MAITLAND CITY COUNCIL

08 August 2011

**RE: Transpacific Liquid Waste Facility (MP05_0037), Rutherford
Modification 3: Amend Emissions and Monitoring Conditions**

Figure B.4: Predicted 24-hour average PM₁₀ concentration

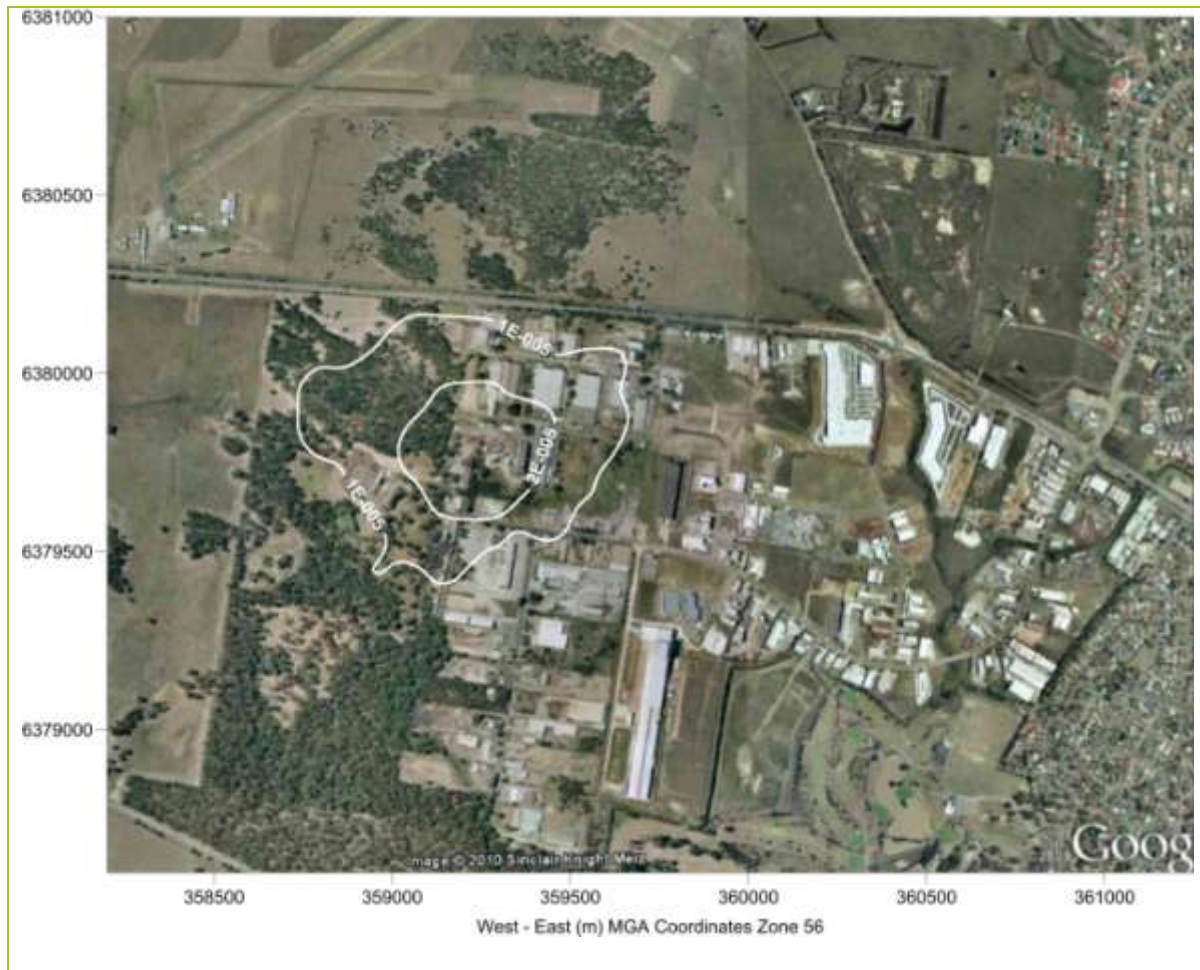
- There is no mention of cumulative impacts of solid particles from other surrounding industries. Given the contour mapping appears to suggest that the 24hr PM₁₀ exceeds if the units versus the guideline units are different, then there may be cause for caution.

- It should be noted that most of the contour mapping is not able to be interpreted as there is no explanation of the contour titling.
- Odour complaints from community - it is our understanding that OEH are aware of complaints from the community in the nearby residential area regarding odour emitted from the Rutherford Industrial Area. As this particular industry is not licensed by Council, Council does not have a
